WEST SUSSEX COUNTY COUNCIL CONSULTATION

| LOCATION: | Former Waitrose Site Avon Road Littlehampton BN17 6AT |
| SUBJECT: | LU/76/25/PL Demolition of vacant supermarket building and erection of four-storey hotel with ancillary restaurant, public realm, landscape improvements, retention of associated car park and all associated works. This application affects the setting of listed buildings and affects the character and appearance of the East Street Conservation Area and is in CIL Zone 4 (Zero Rated) as other development. Amended plans - Substitute Proposed Site Plan 6122-P-002 Rev.C Supplementary Highways Response - 10th June 2025. |

Proposed Site Masterplan

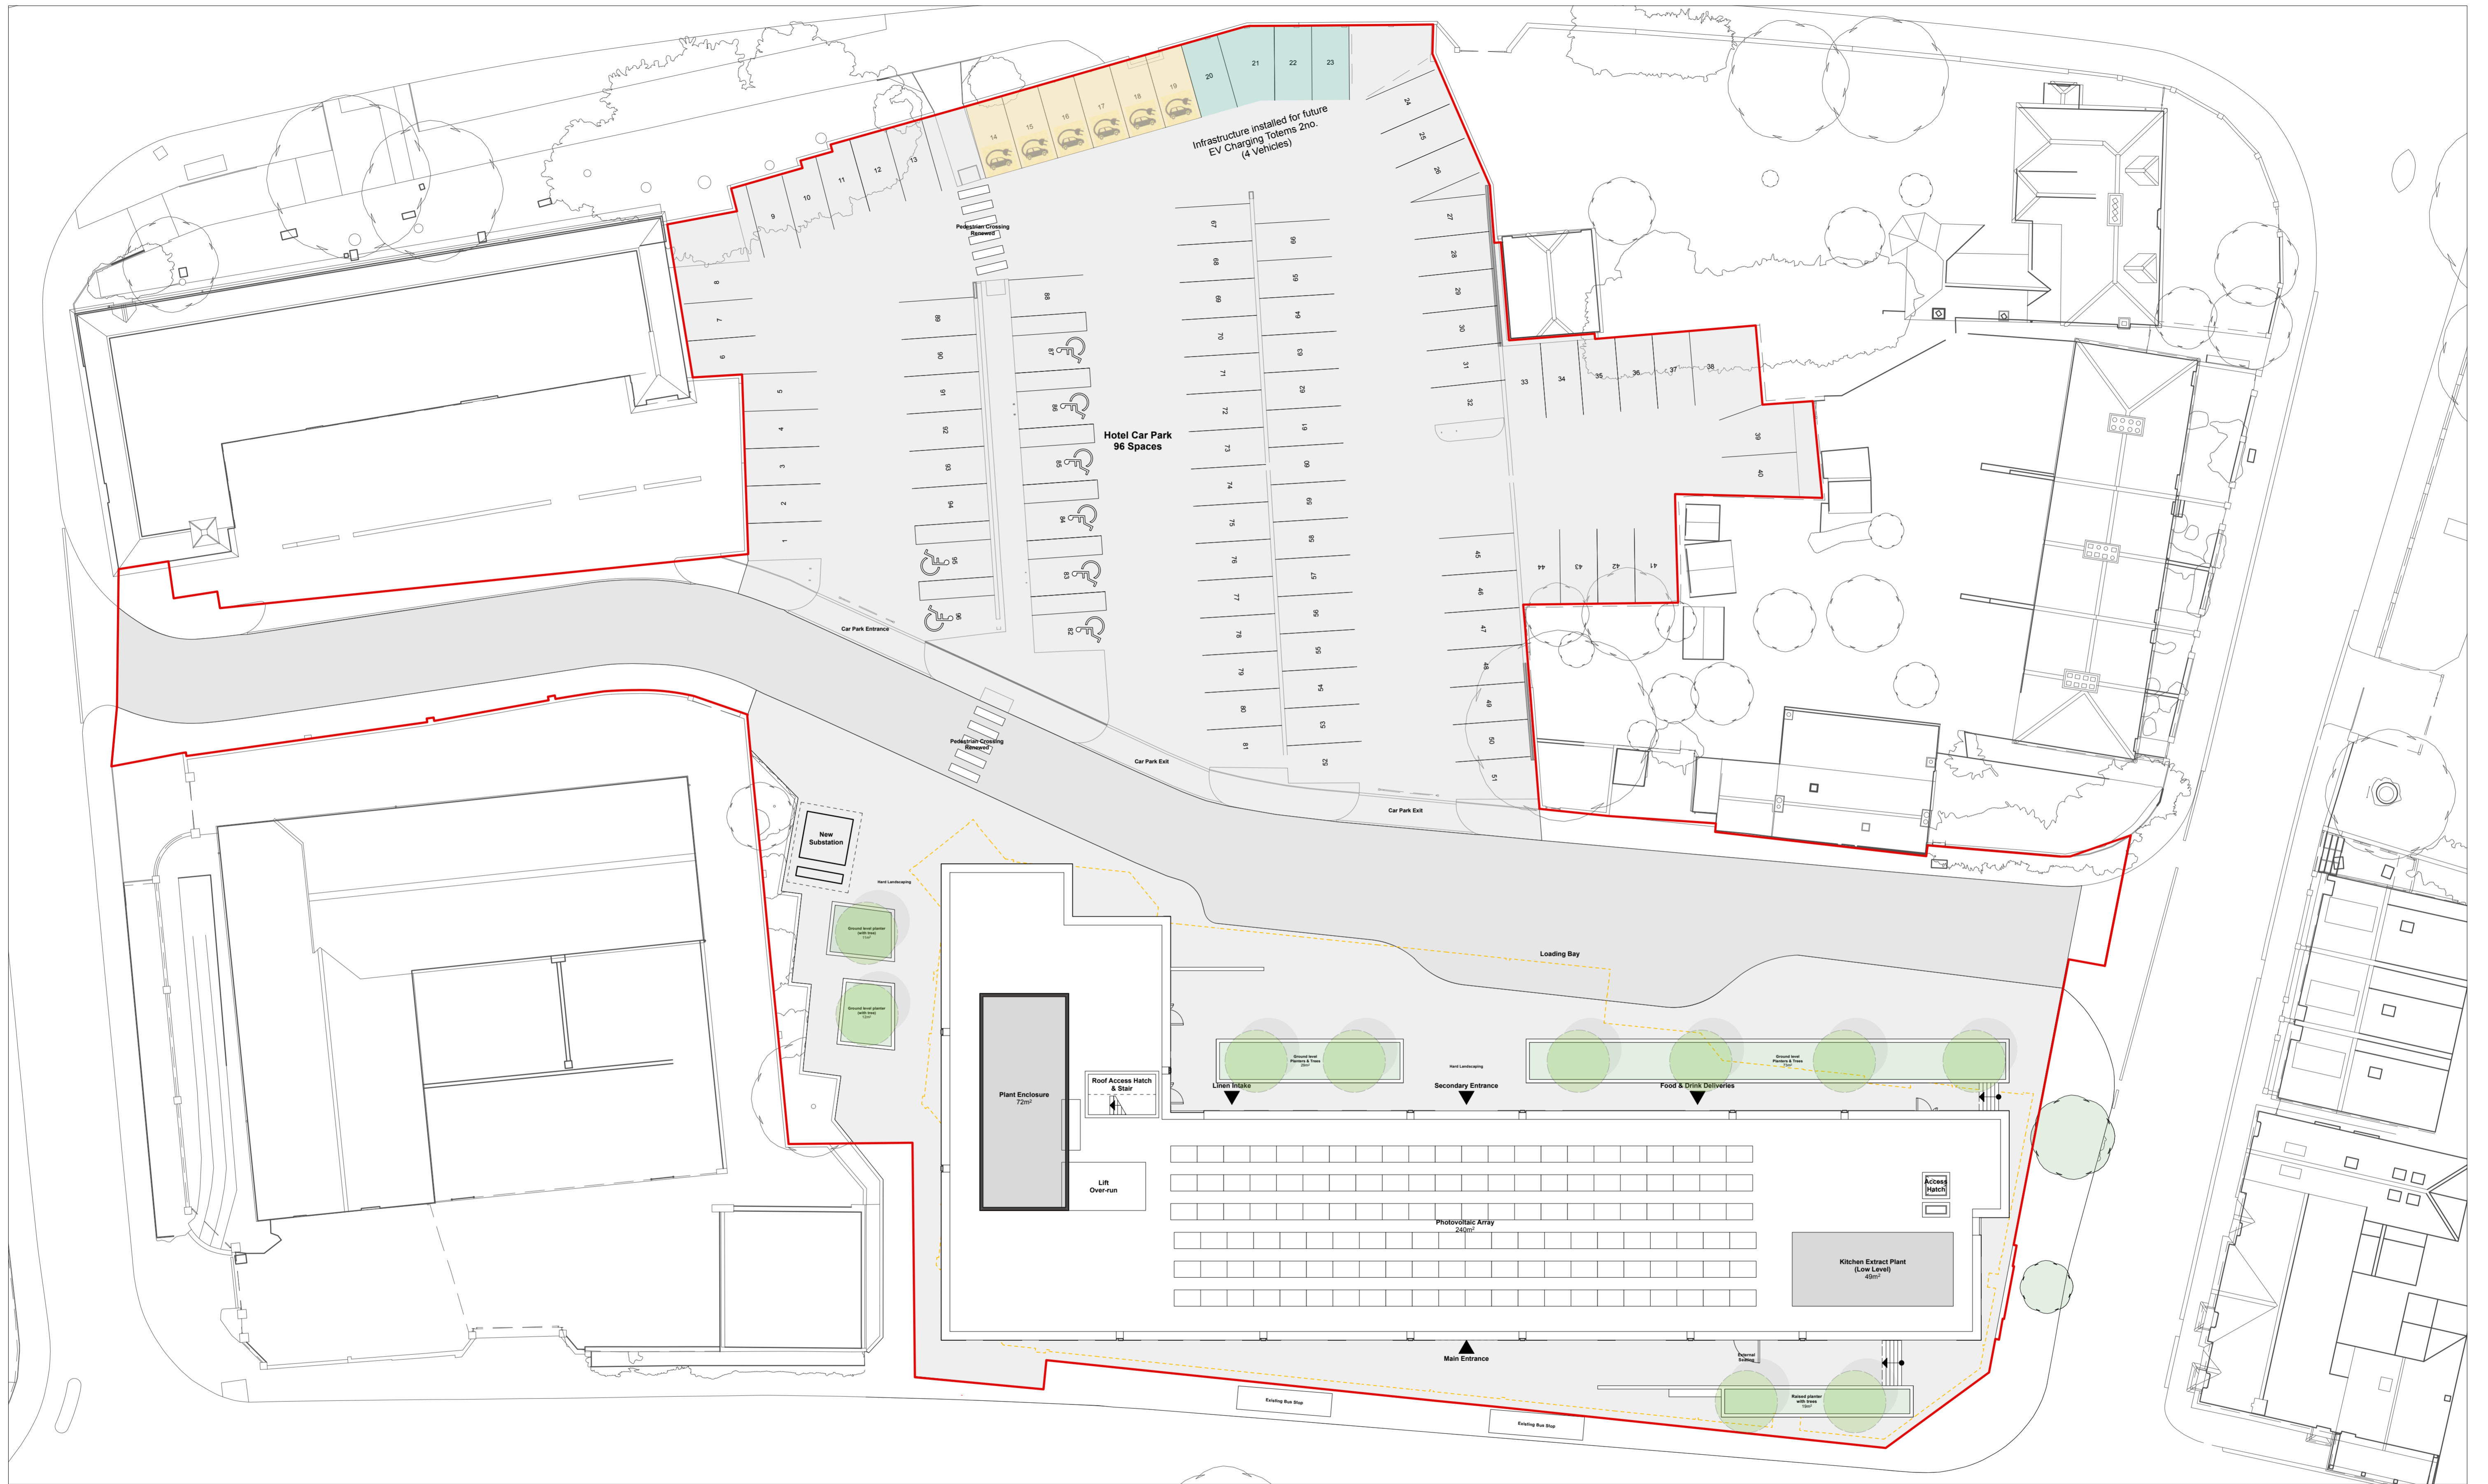
● **All plans to reflect parking layout inc. disabled/accessible hatching and changes made clear and clarify staff parking arrangements.**

● **Car park access/egress/directional signage**

Site Plan has been updated to include hatching for disabled bays. Some works would be required to the car park spaces to remove child/parent space markings. Car park signage for entry/exit points has also been indicated. All these details and car parking lining modifications can be secured by condition. The applicant has not clarified staff parking arrangements but staff could park here or make use of other town centre car parks or use active/sustainable travel modes.
